Your ref:	15 Westbourne Terrace	<b>Please reply to:</b>	<b>Mr Joshua Wilson</b>
Our ref:	24/02229/FULL	Tel No:	07817095455
		Fee Queries:	0207 641 6500;
		Email:	planningreception@westminster.gov.uk;
Mr Sam Mitchell Sashed LTD Studio 26 52-56 Standard Road London NW10 6EU		<b>Incomplete Applications</b> Town Planning & Building Control City of Westminster PO Box 732 Redhill, RH1 9FL	
		23 April 2024

**Address: Flat 3, 15-17 Westbourne Terrace, London, W2 3UN,**

**Proposal: Replacement of single-glazed timber sashes on the front and rear elevations with new replica sashes containing vacuum-insulated glazing, fitted into existing frames and painted white. (Linked to 24/02230/LBC)**

Document Name: Existing items 1,2,3
 Issue Date: 15 March 2024
 Document Version: 1.0

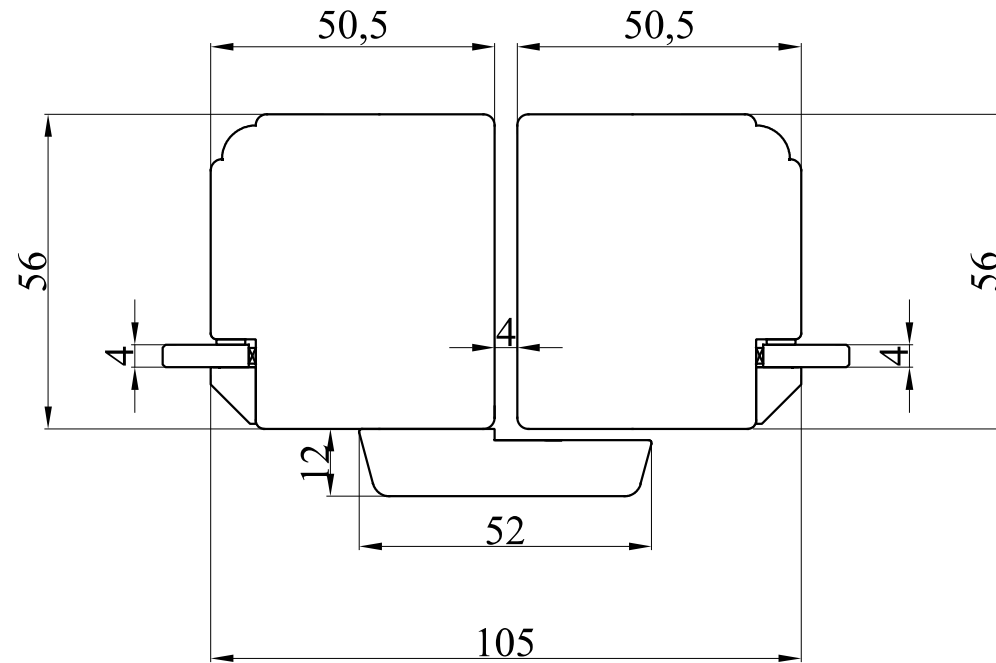
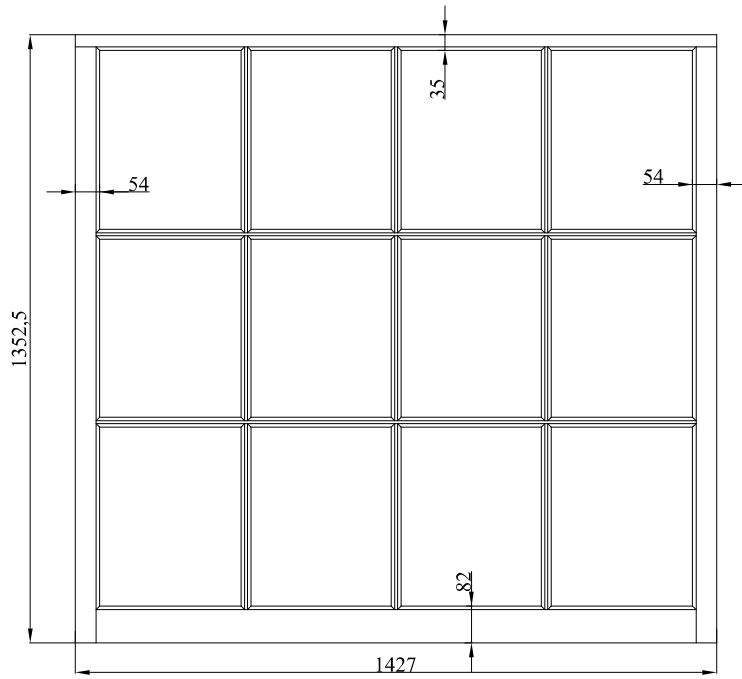
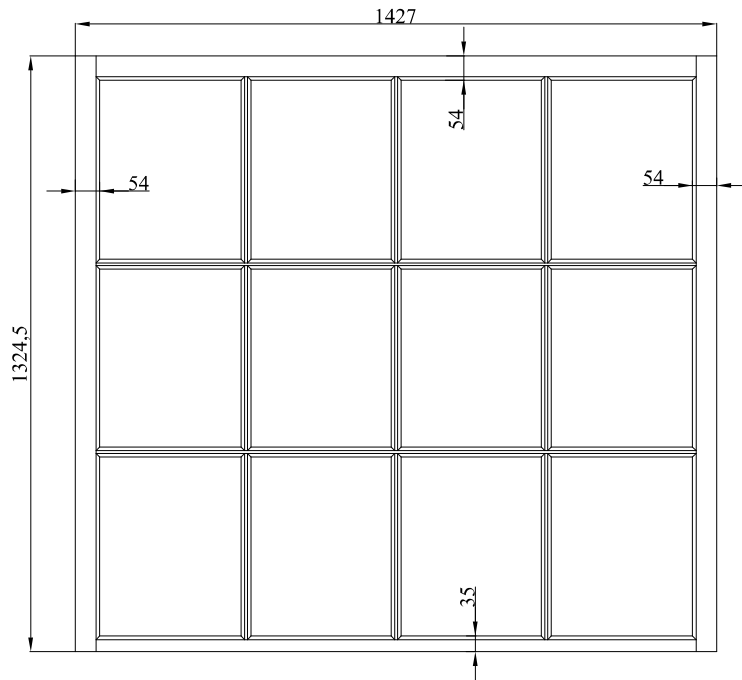
- The existing drawings do not match the photographs of the detailed profile of the frames in the photographs.
